Re: Desert Sands Subdivision Preliminary Plat, DRB# 1005224

Attached please find a revised Infrastructure List, Preliminary Plat, Grading Plan, and Sidewalk Exhibit incorporating revisions to address the comments received at DRB on Feb 17, 2016. The comments have been addressed as described below in red.

CITY PROJECT NO.	ZONE MAP NO.	SHEET	OF
		3	5

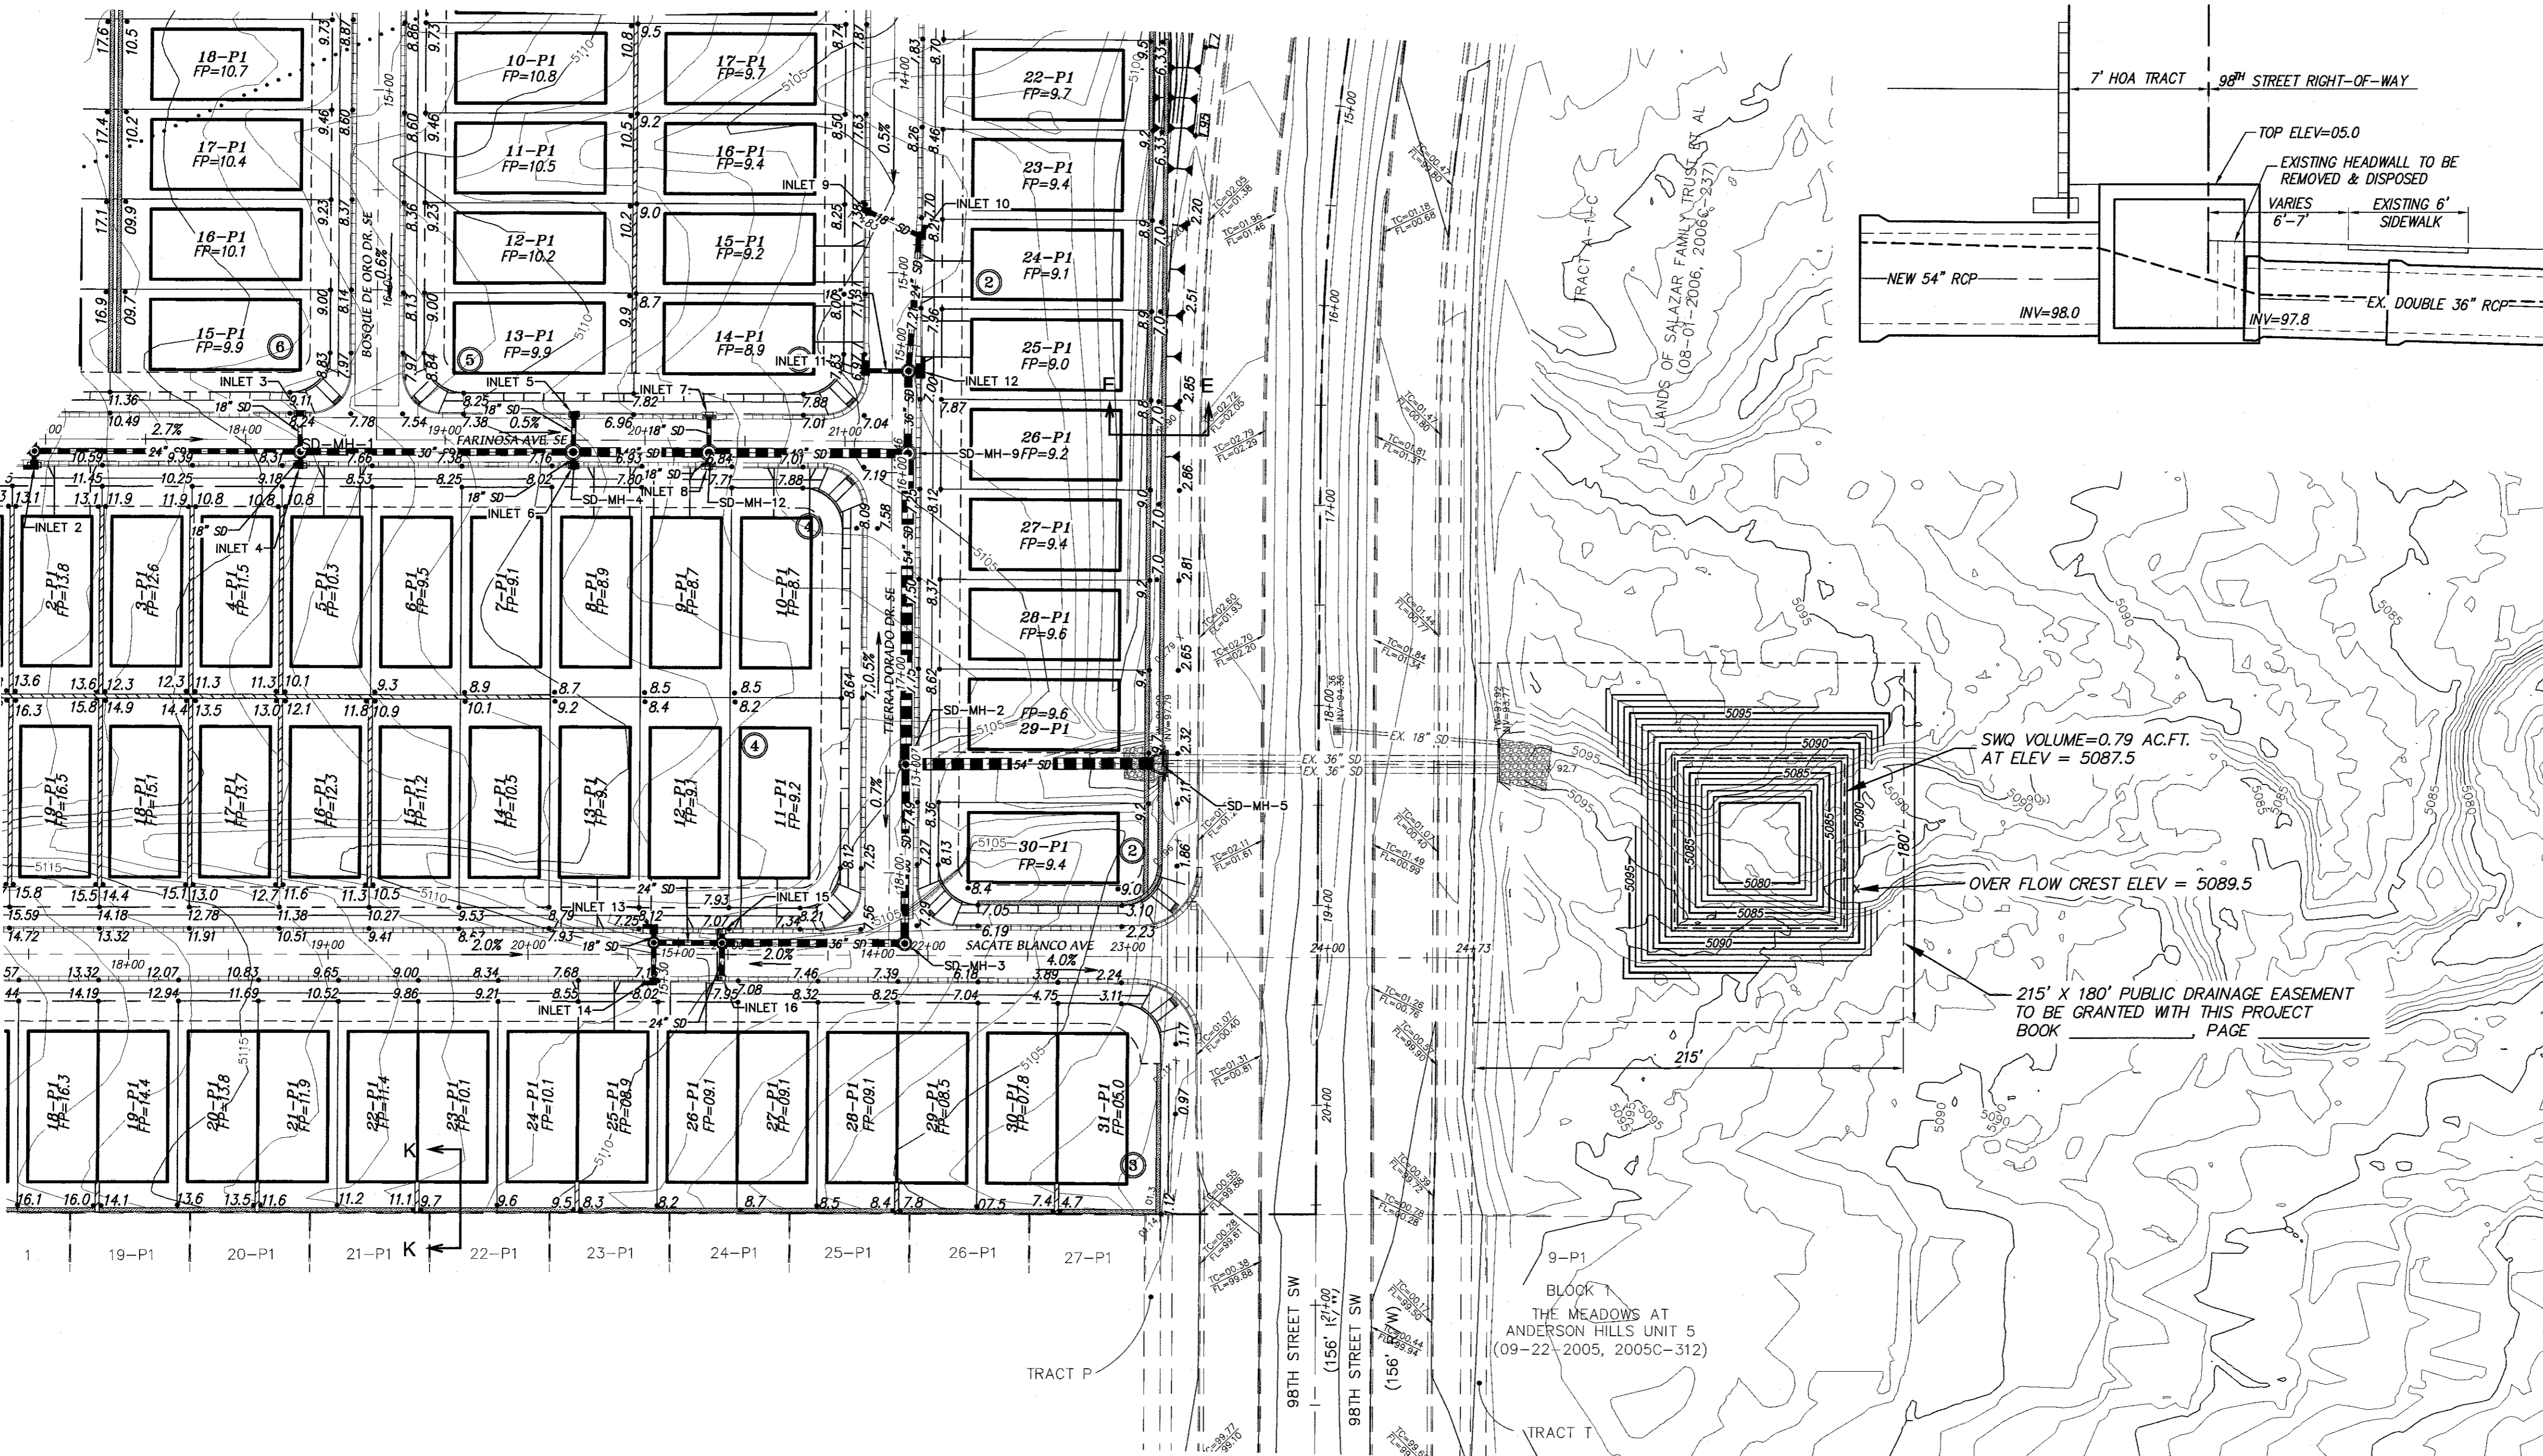
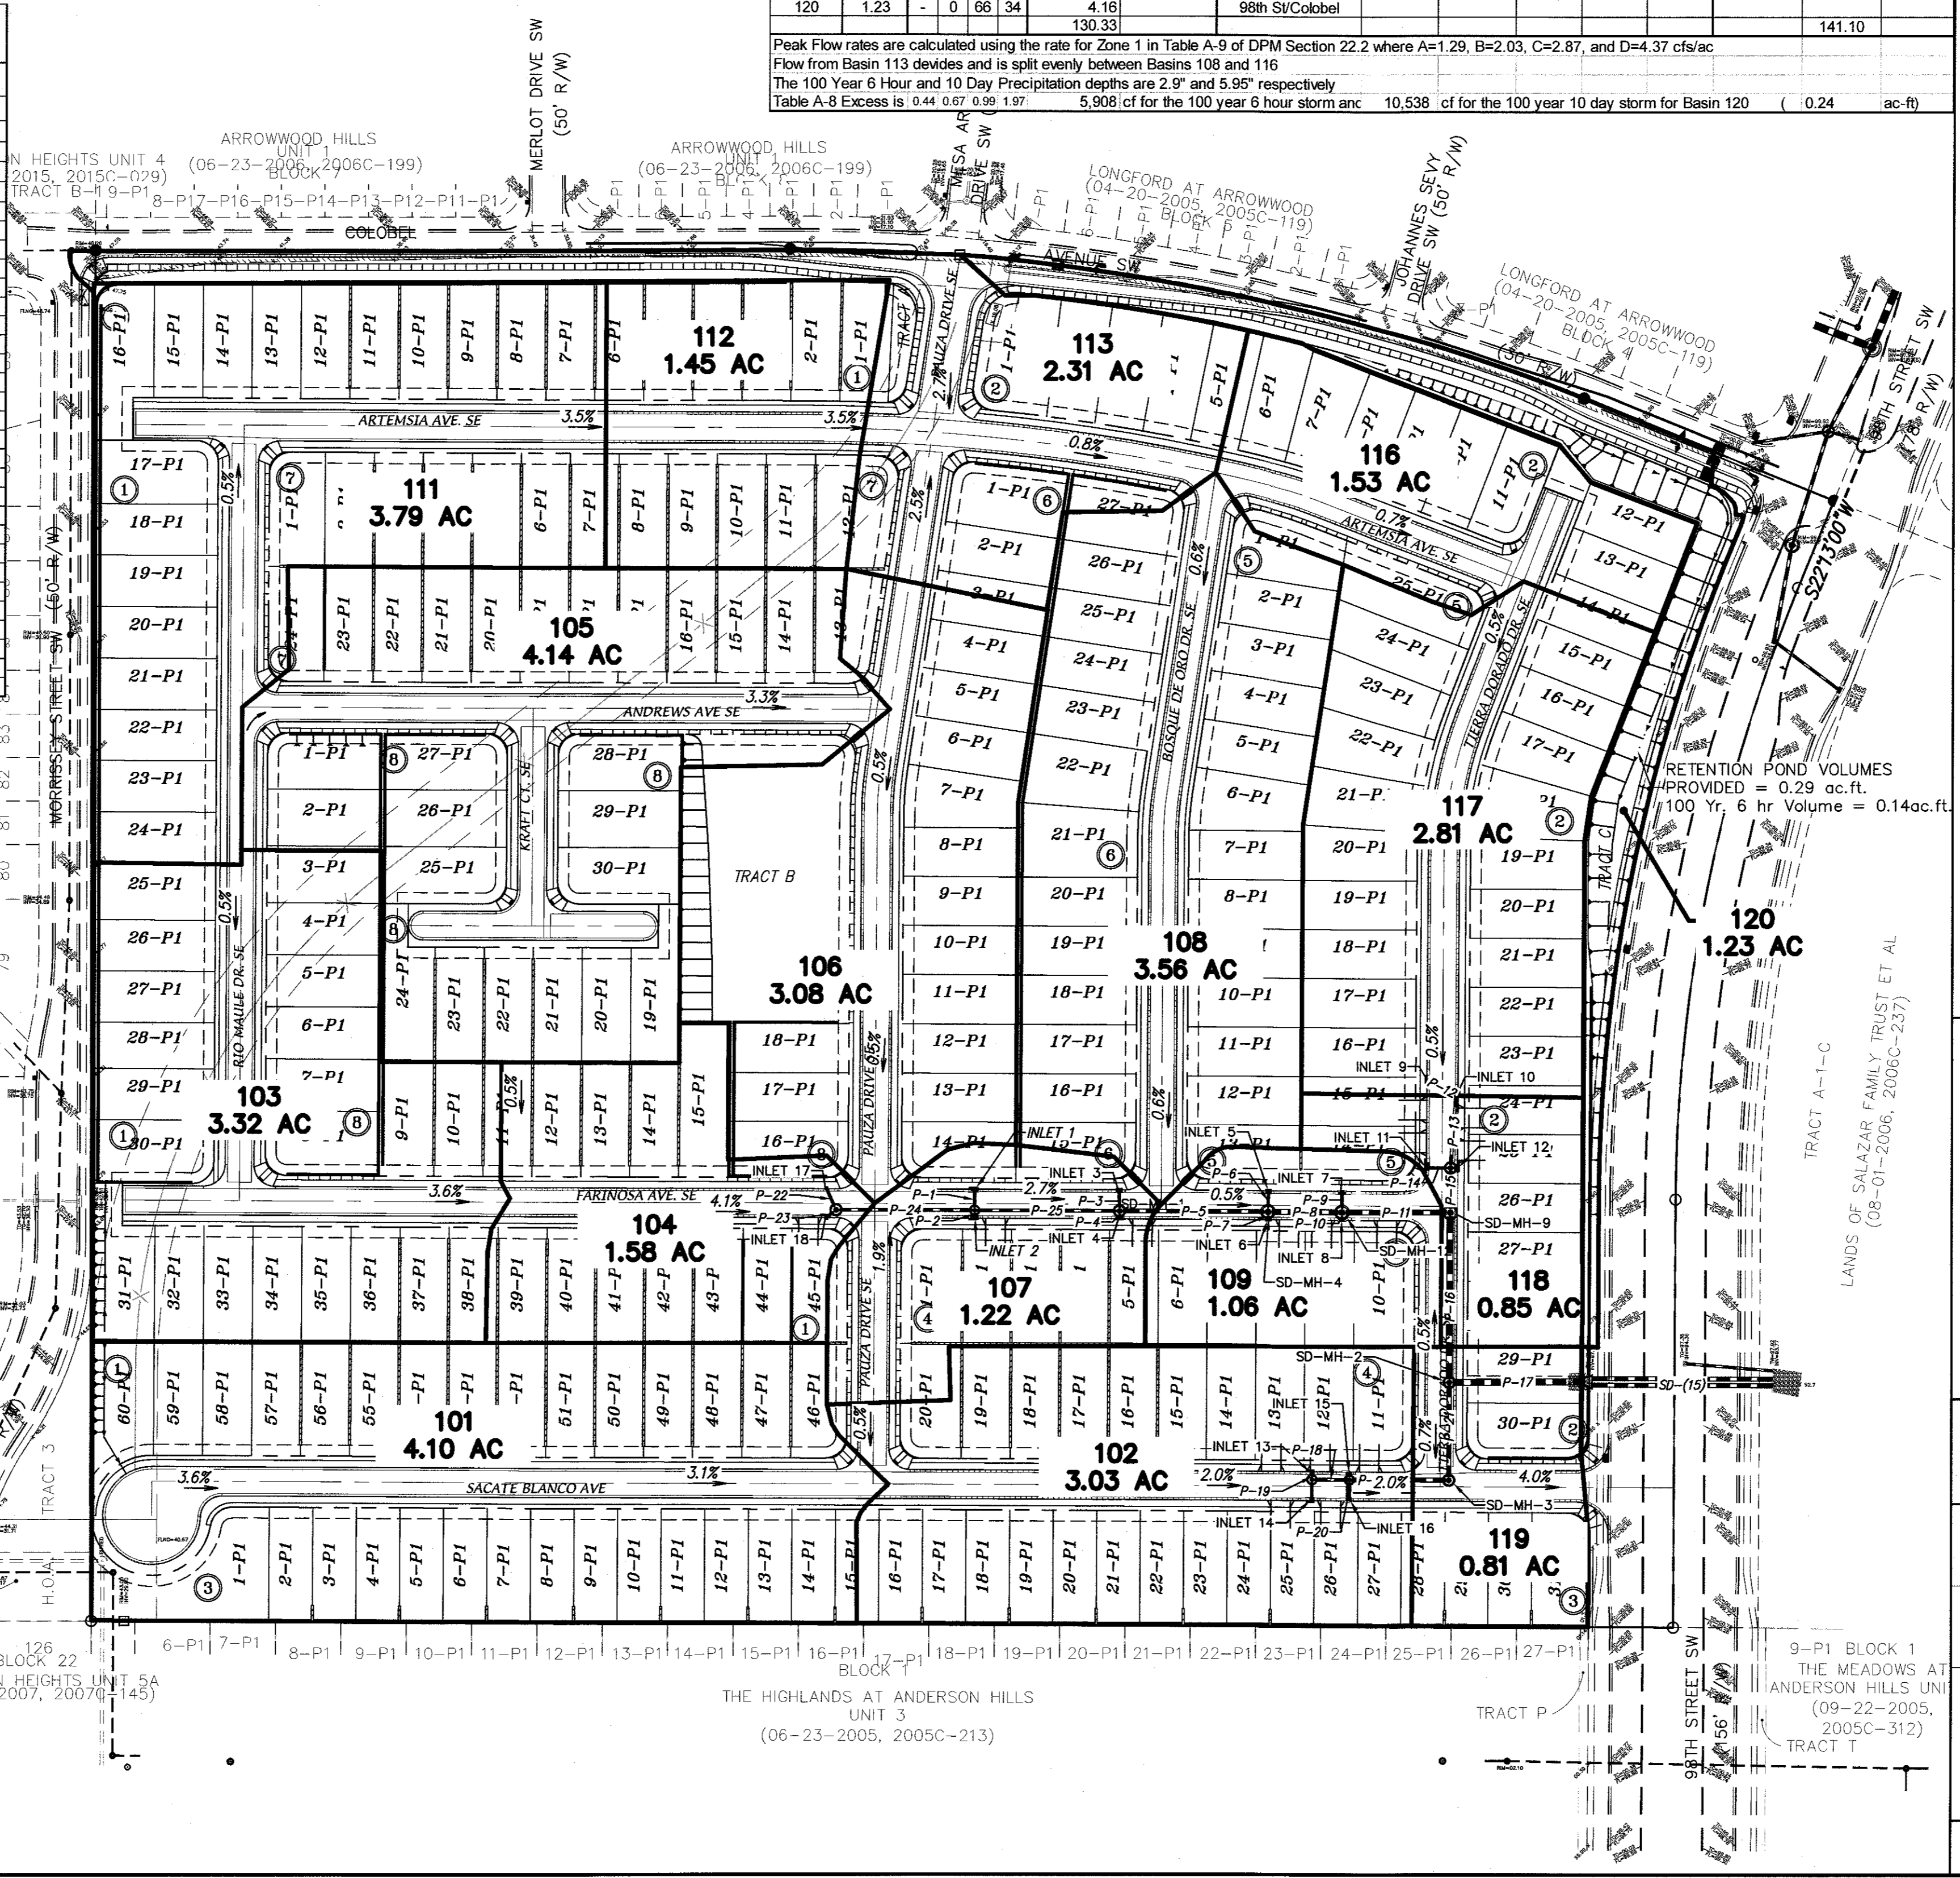
- 1) *Preliminary Plat, Infrastructure List, Grading Plan, Utility Plan*
 - a) *Pro rata is duly noted.*
 - b) *Service Requirements*
 - i) *The Grading Plan has been revised to lower the elevation of the lots on the west side of the project so that none of the pad elevations are above the 2WR elevation of 5140 (NAVD 27/29).*

Additional pedestrian connections have been added to sheets 1,2,and 4 of the Grading and Drainage Plan and to pages 3 and 6 of the Infrastructure list. Pedestrian easements have been added on the Preliminary Plat.

**CURB & SIDEWALK
DIMENSIONS EXHIBIT**

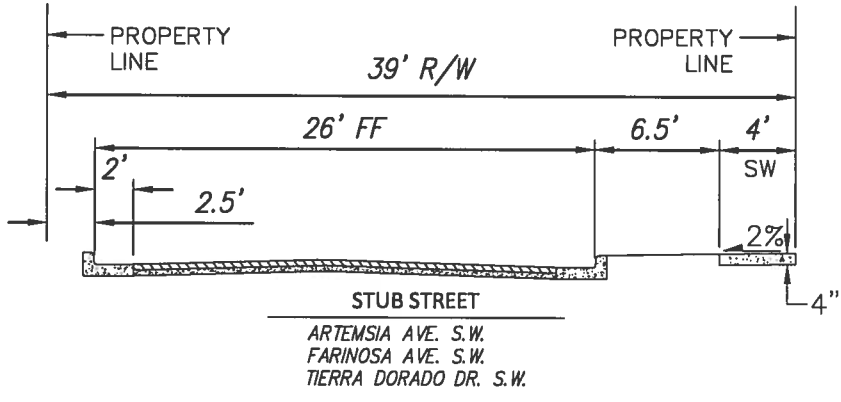
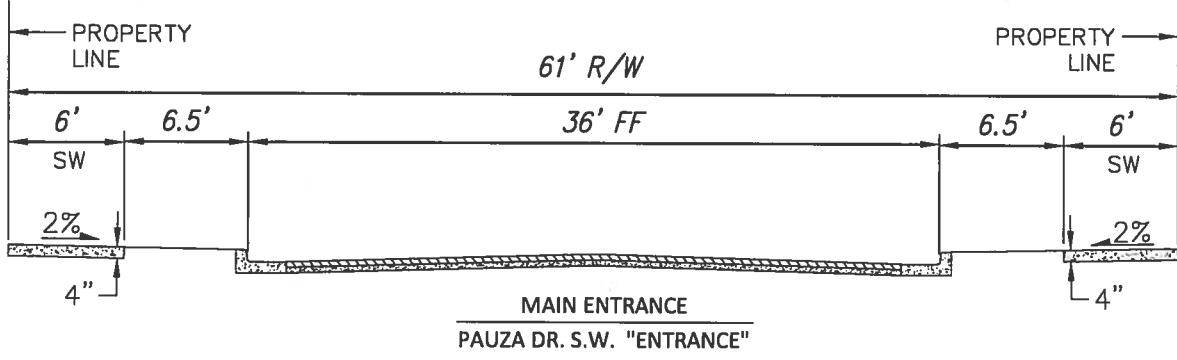
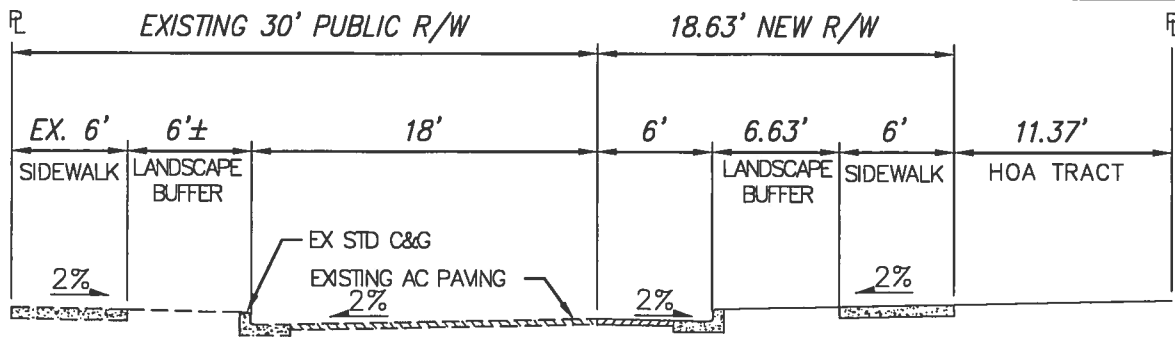
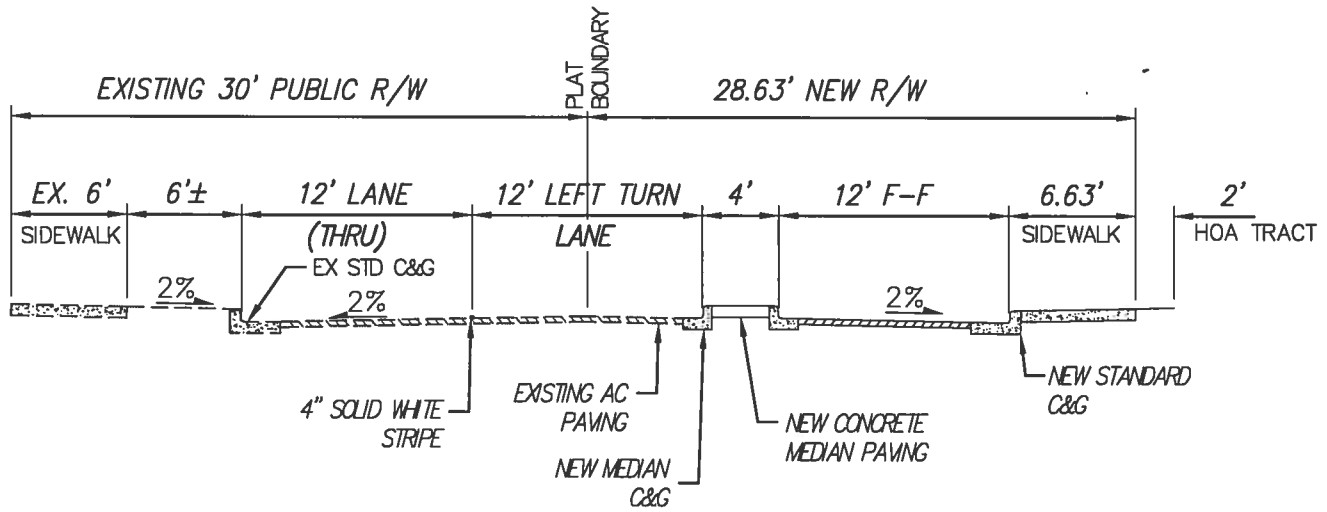
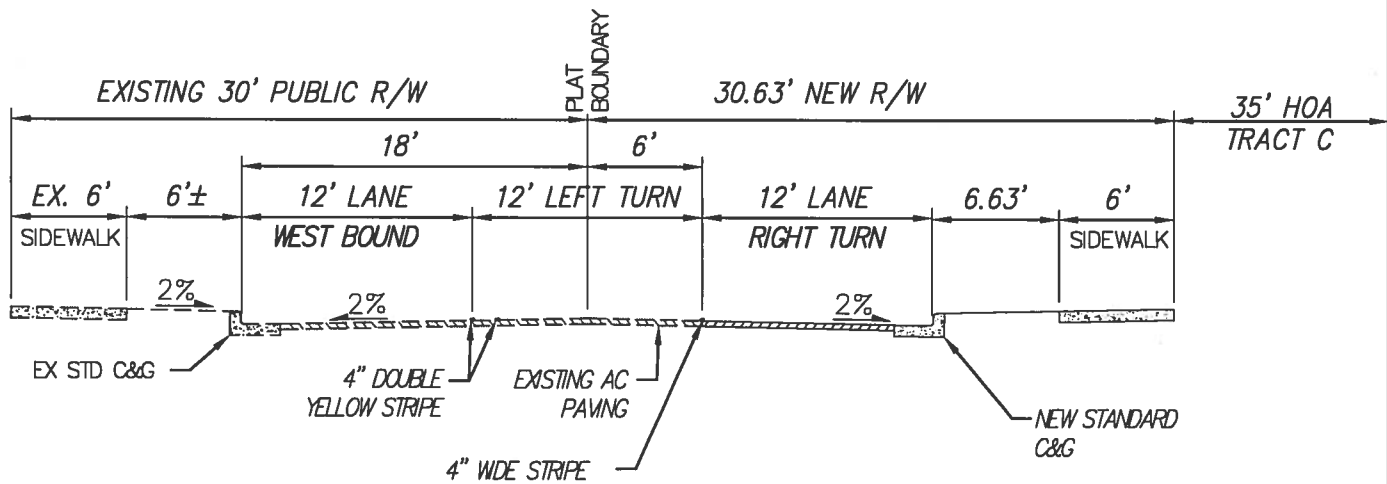
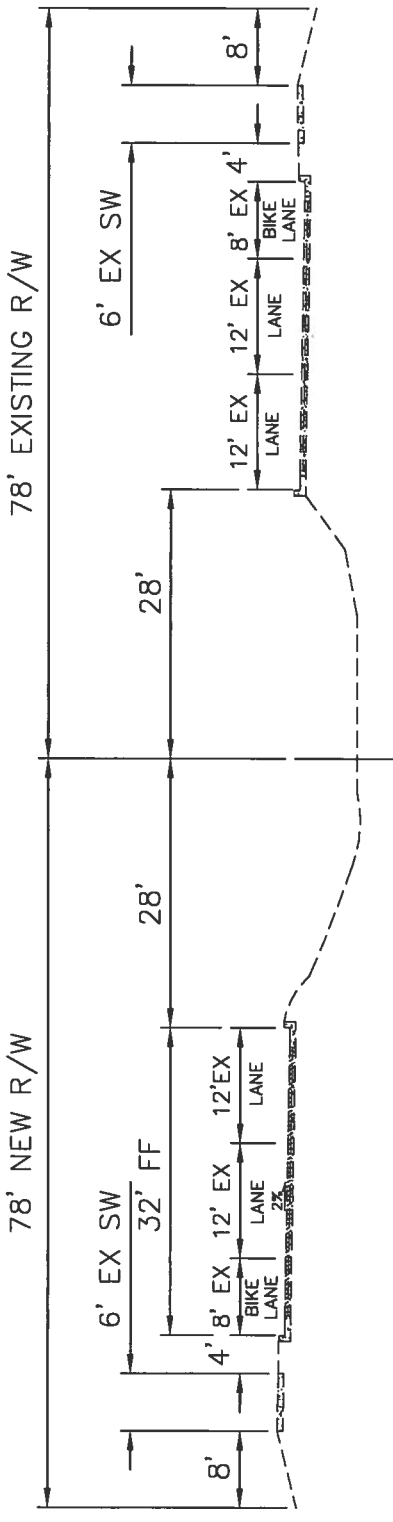
- 2 Cross sections have been added showing dimensions to the Curbs and Sidewalks on 98th St, Colobel Ave, and Morrissey St.
- 3 A sidewalk has been added to Kraft Court on the south side of the hammer head on page 6 of the Infrastructure list and on the Sidewalk Exhibit.

- 9 See comment 7 above.
- 10 The unit boundary has been replaced with lot and block numbers on page 5 of the Infrastructure list.
- 11 The roadway widths have been corrected on two of the typical sections on the Curb and Sidewalk Exhibit.
